# Roadway Plans\_V1.pdf Markup Summary

# CLEARWAY FILING NO. 2, LOT 5

# CONSTRUCTION PLANS

**STORM 2**  
**STA 1+00.00 TO STA 4+41.70**

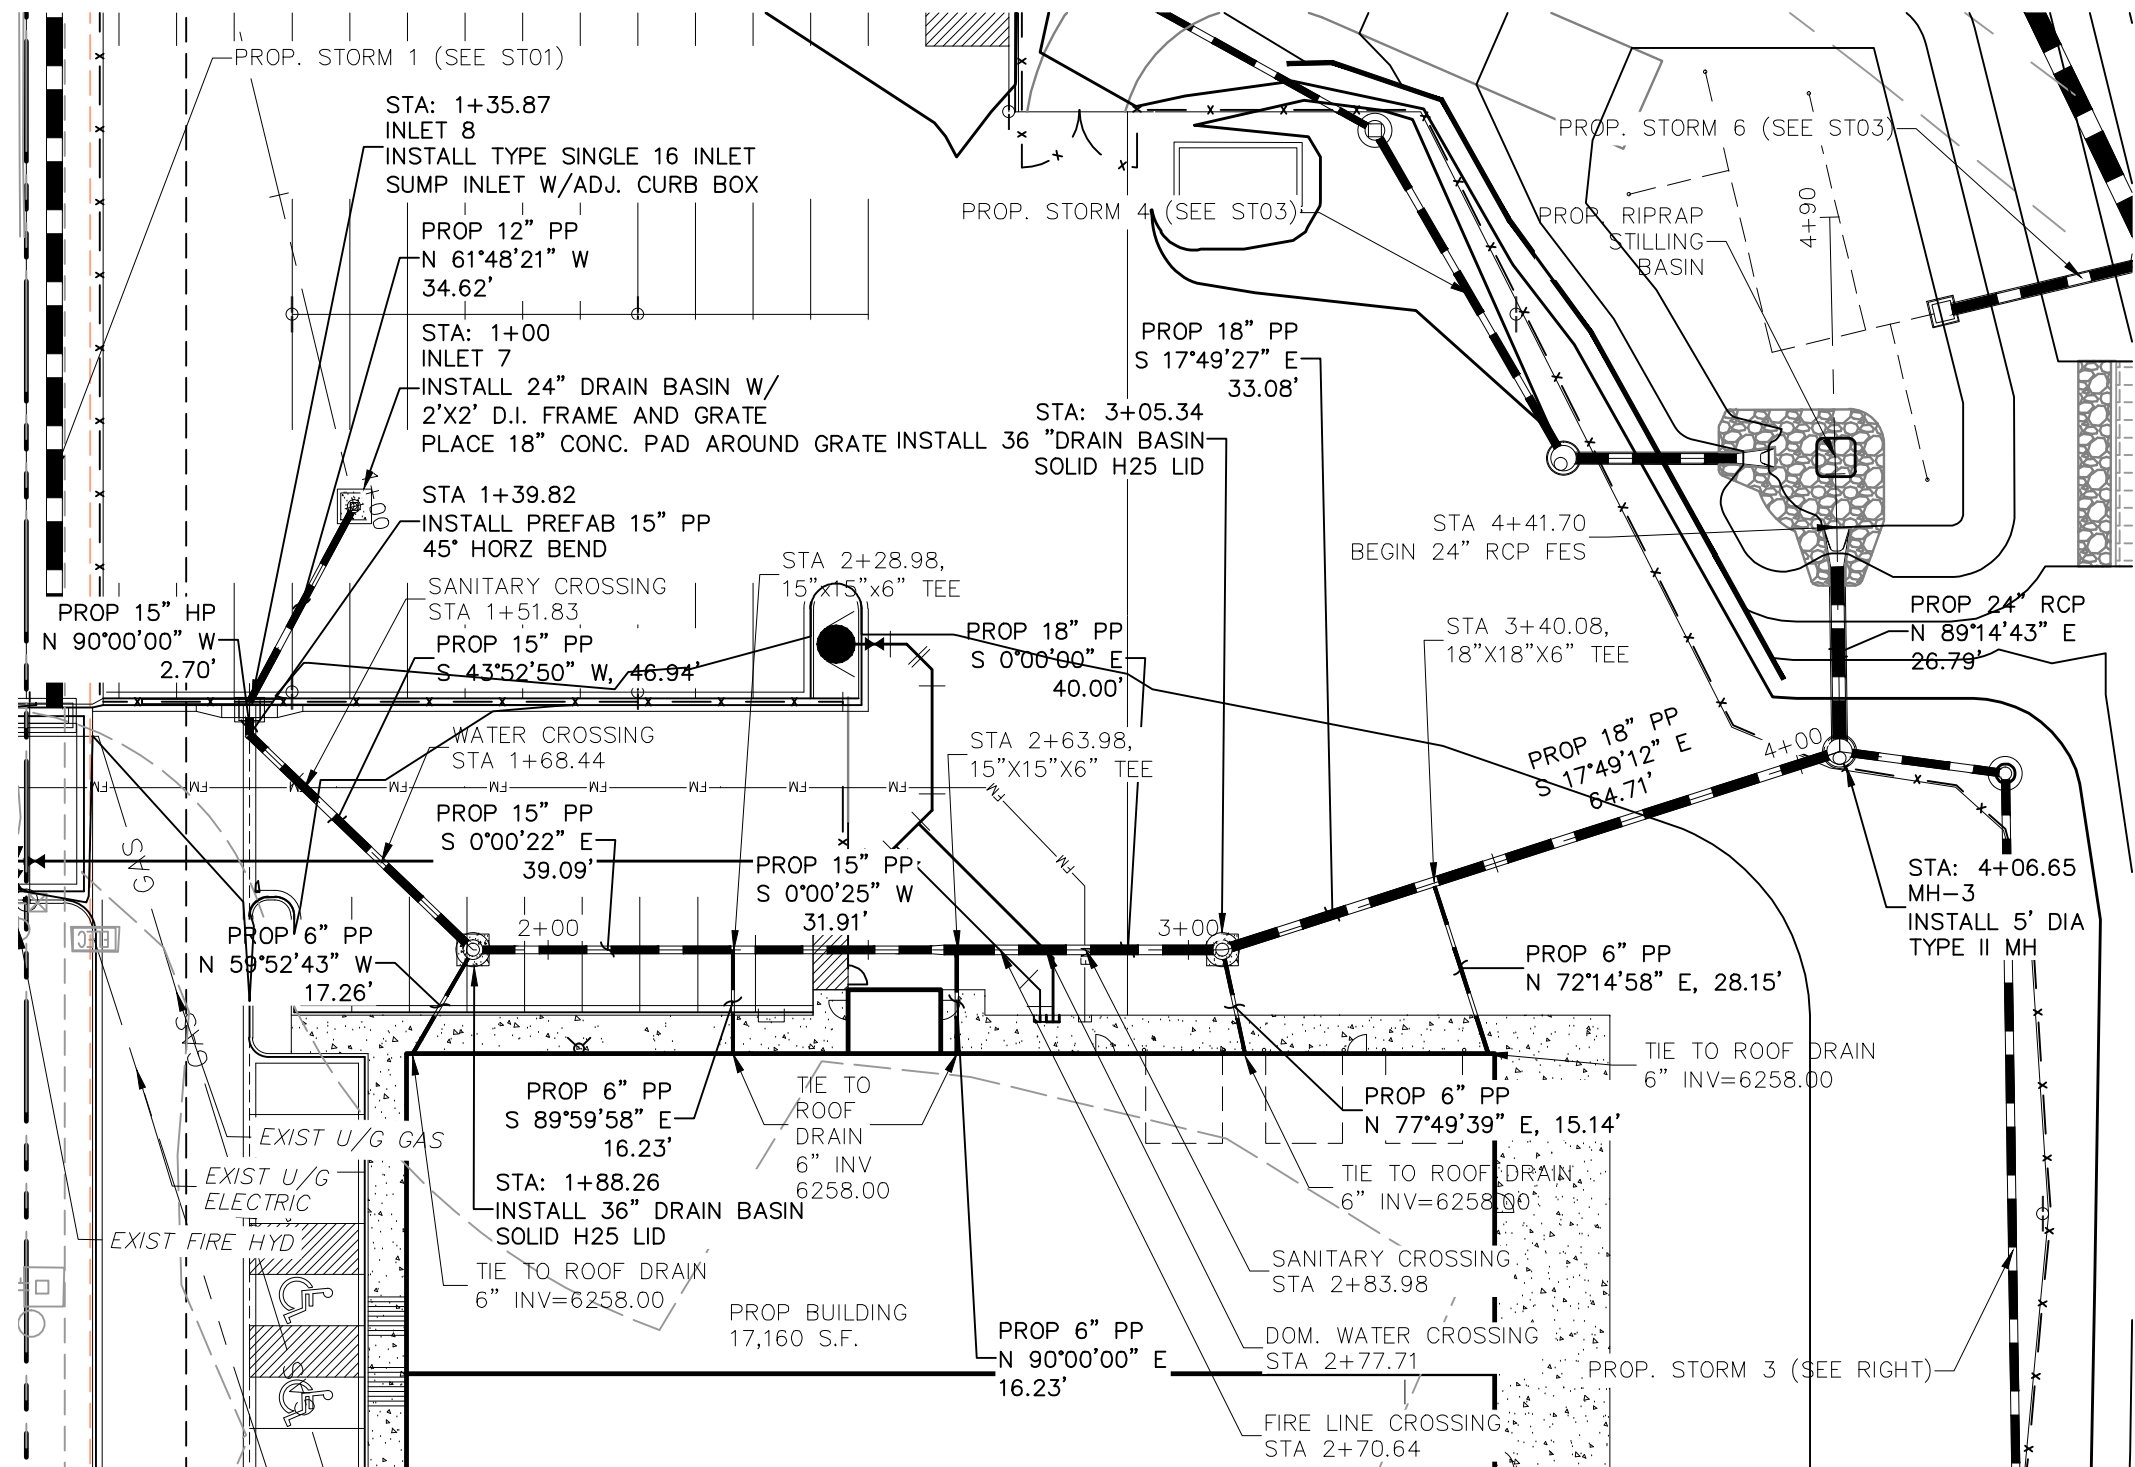
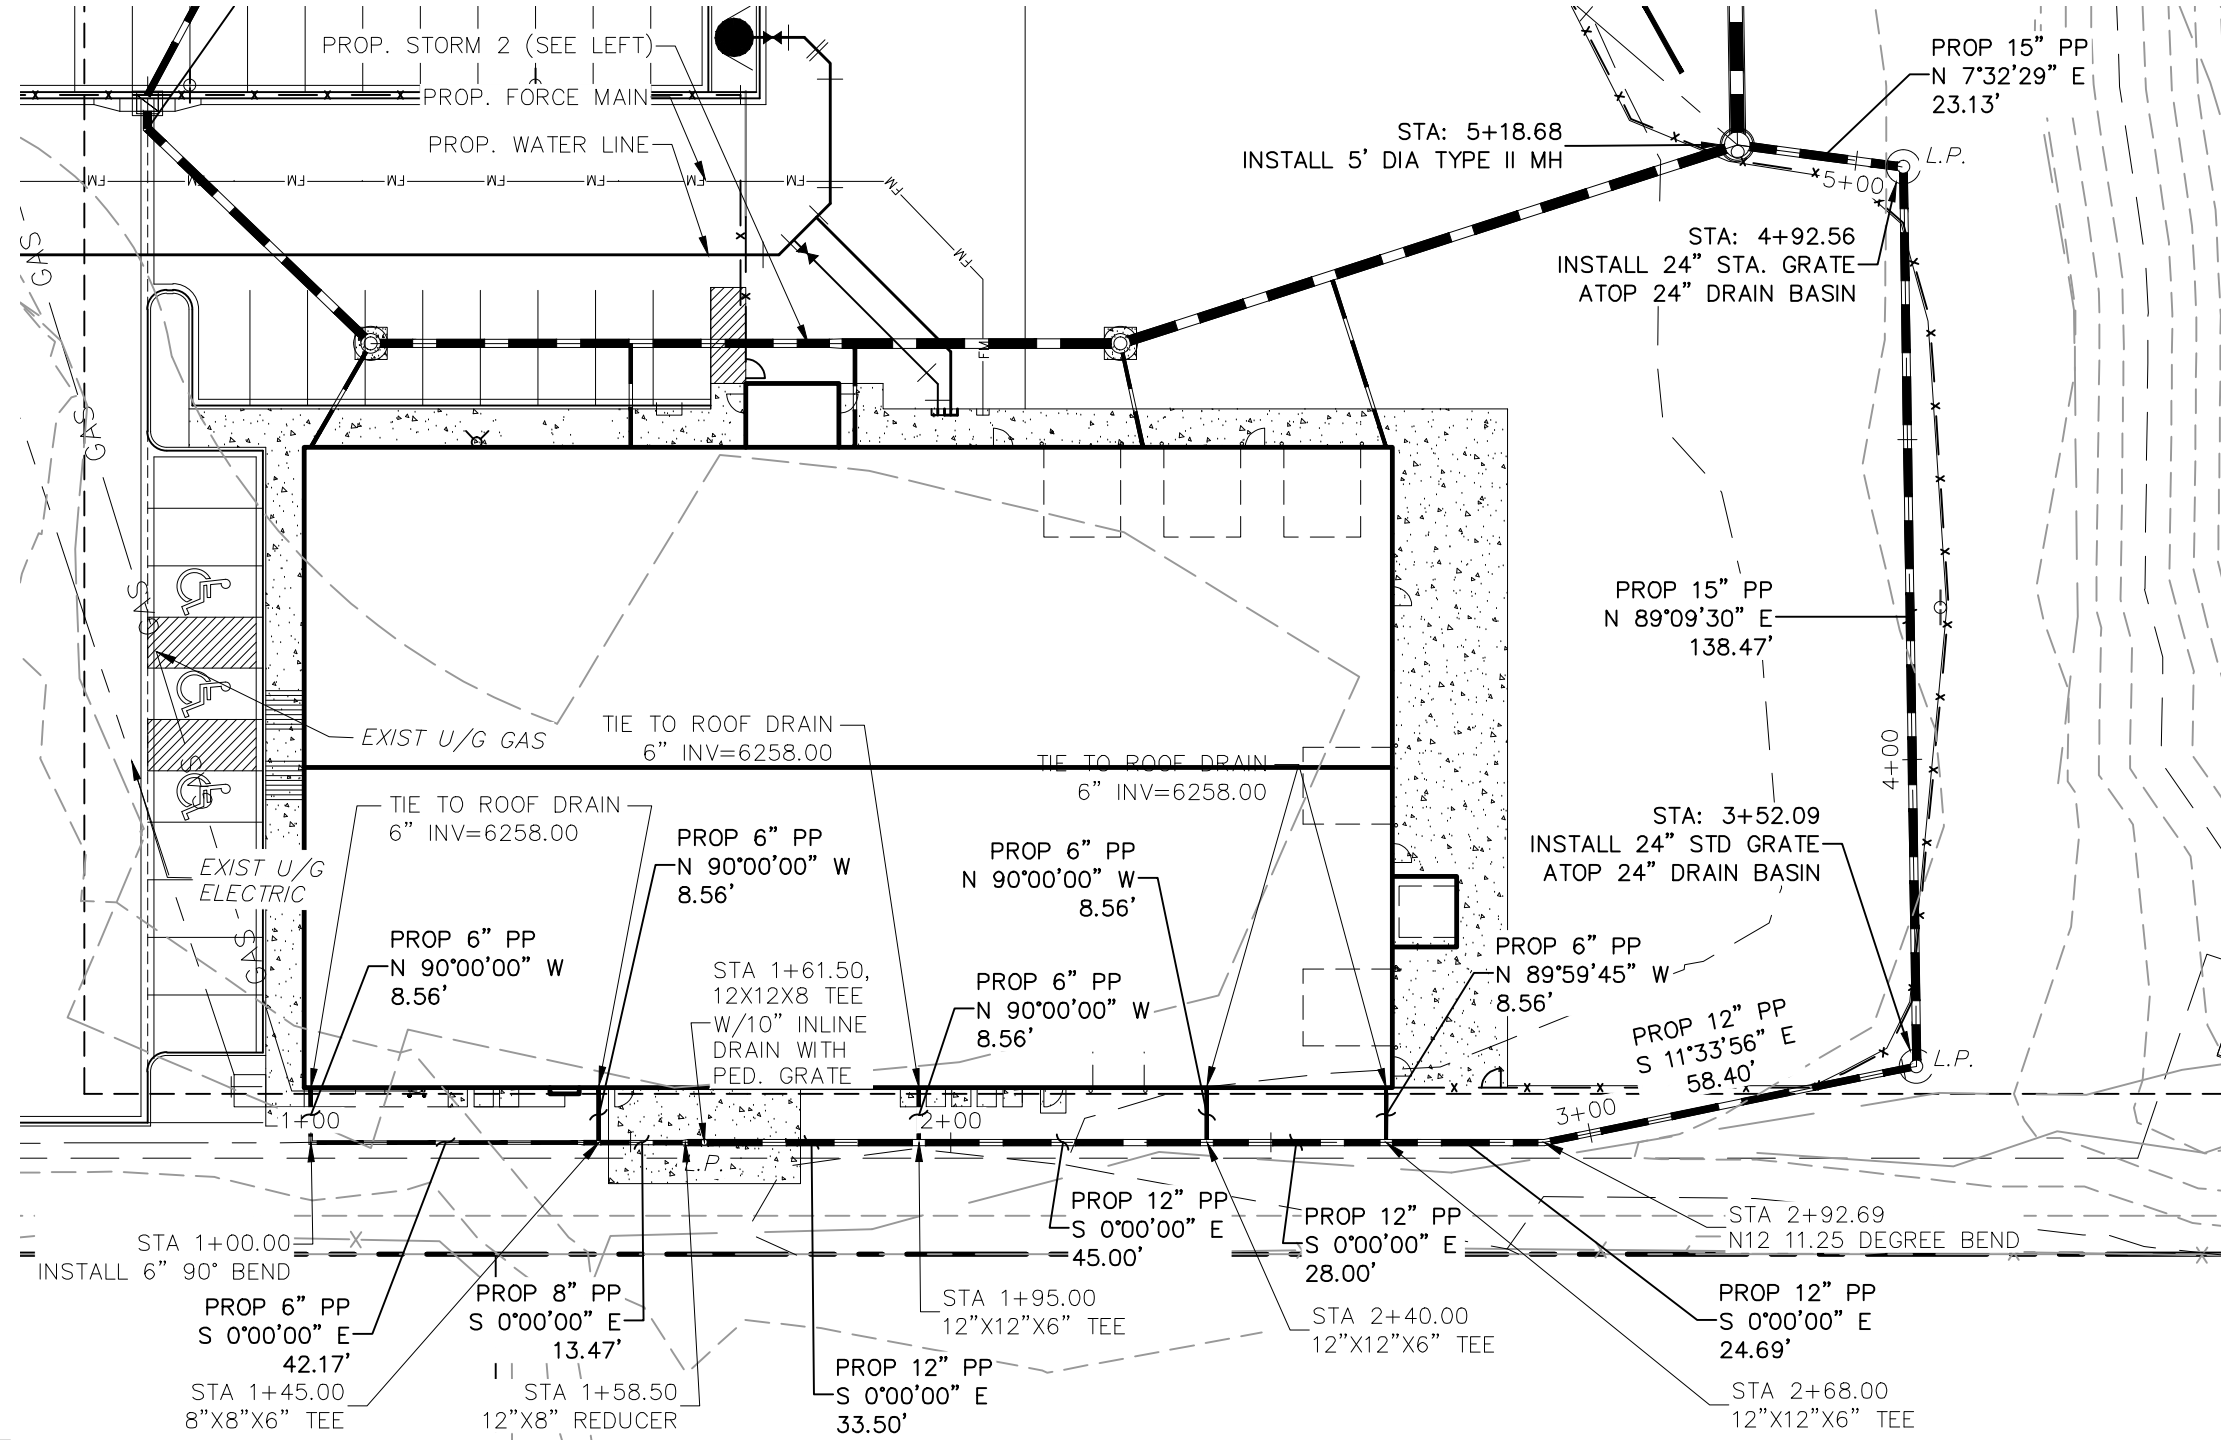
Show HGL lines on the profiles.

provide vertical scale

identify the depth of the basin
